Memorandum
Department of Planning and Development
Historic Preservation Office

To: Chair Morrisette and Members of the Planning Board
From: Deborah Andrews, Historic Preservation Program Manager
Date: October 4, 2012
Re: Proposed Hotel at Northeast Corner of Fore and Union Streets -
Historic Preservation Board's Analysis of Historic Context,
Comments on Preliminary Design Proposal

**NORTH
ELEVATION**

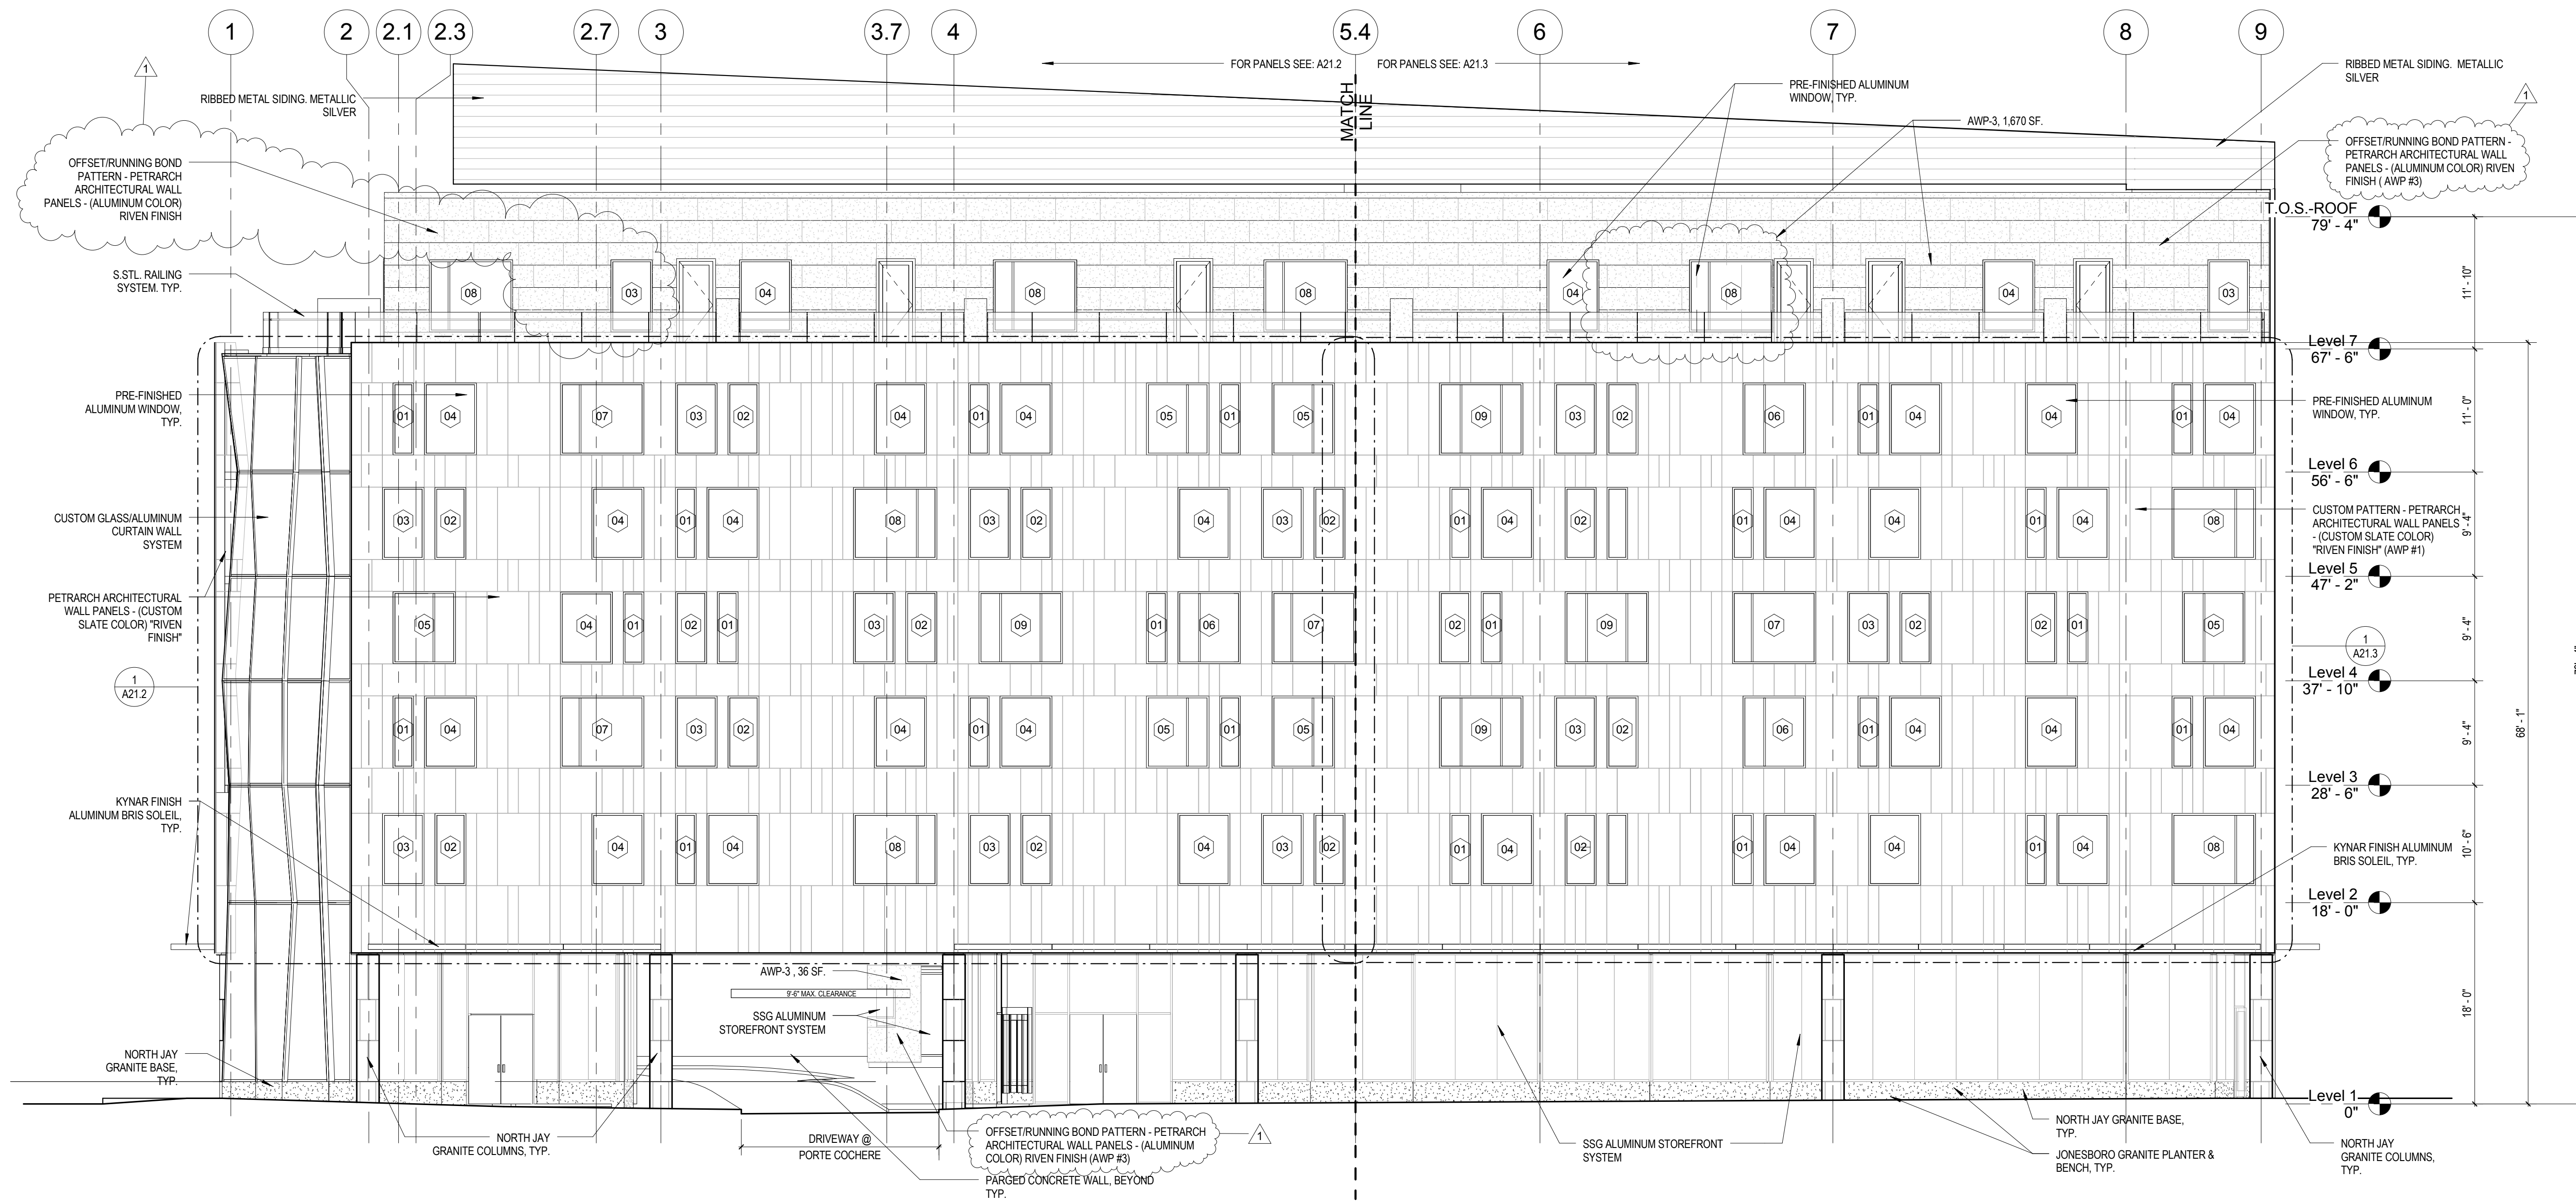
- Board members noted that the rooftop mechanical screen adds to the overall perceived height of the building and urged that it be lowered in height to the extent possible and de-emphasized.

- Board members stressed the importance of providing architectural interest to the rear or north elevation of the building. Given the presence of the CMP transfer station, it is likely that this façade will be highly visible for the foreseeable future and should not be treated as a strictly secondary façade.

**SOUTH
ELEVATION**

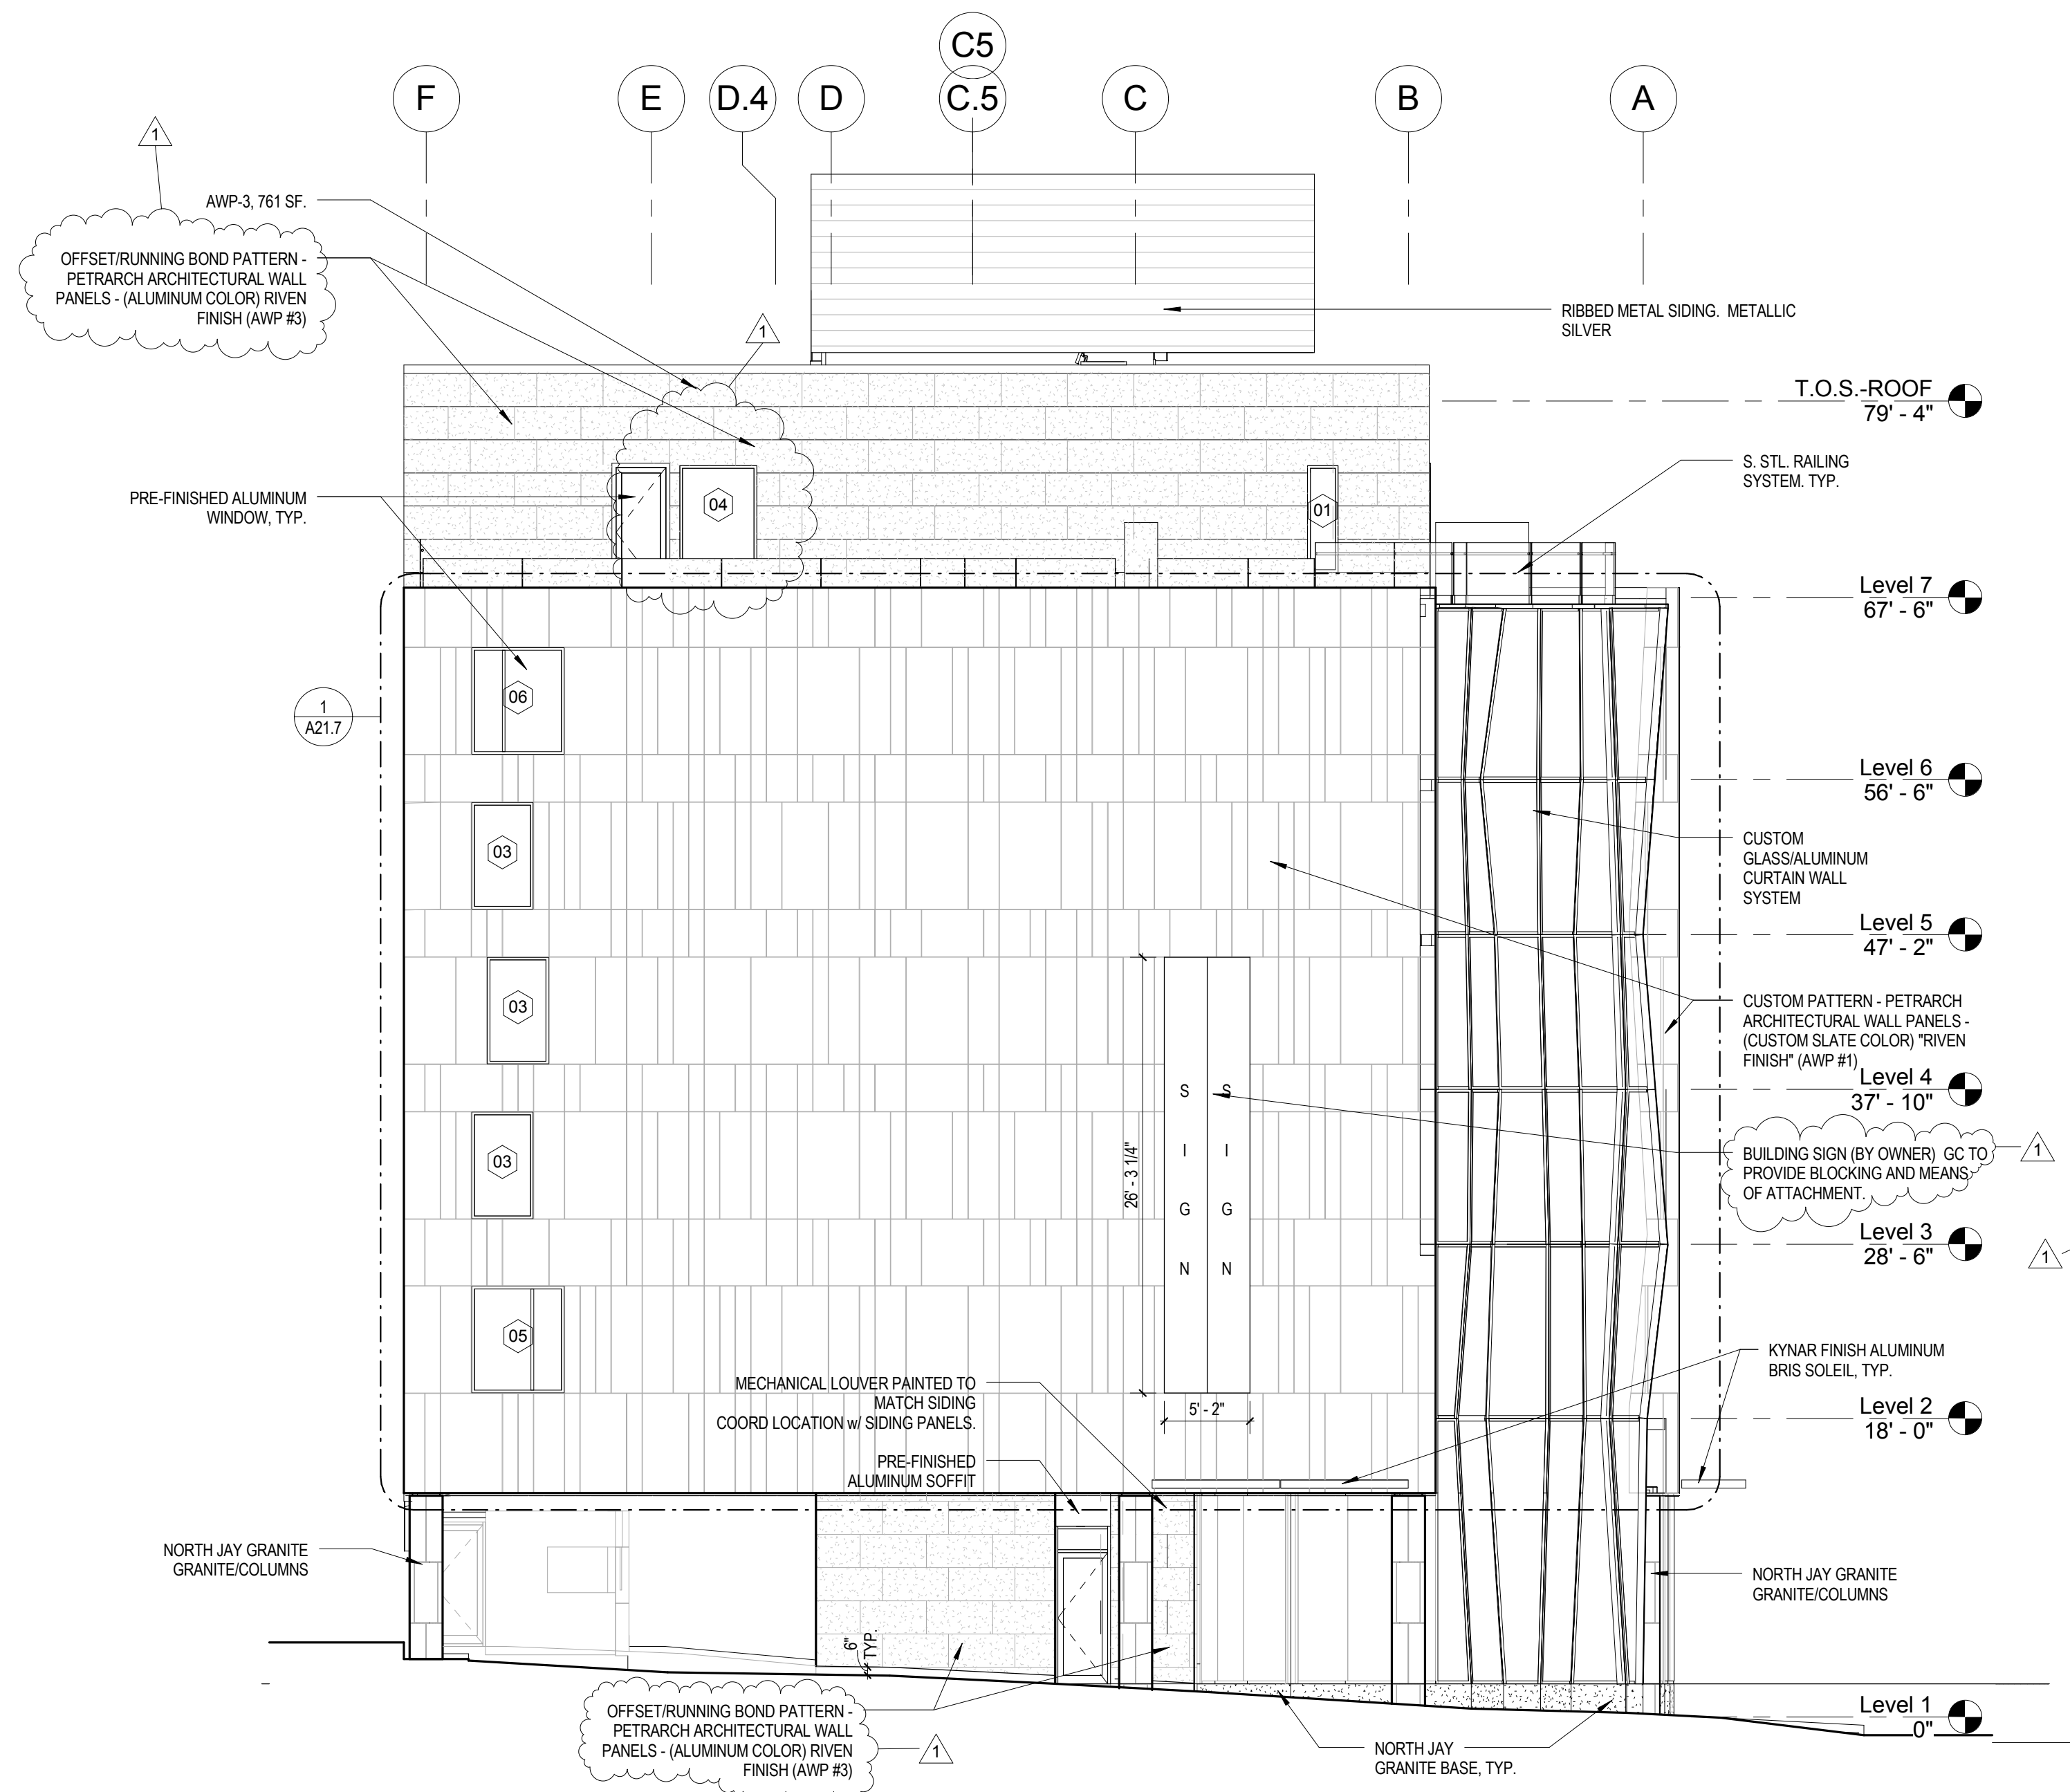
- The Board was generally supportive of the treatment of the ground floor level. They noted that the proposed height of the ground floor (11’4”) was consistent with the base heights of the historic buildings on Fore and helps create a human scale at the street level. The introduction of sun screens over the ground floor also reinforces this human scale and the presence of regularly-spaced heavy granite columns serves as a reference to the granite piers that define the storefronts on Fore.

- The general proportions of the individual upper floor windows were seen as compatible with those of its historic context. The organization of the windows, which creates something of a “digitized” façade, was a point of debate, however. (See above discussion.)
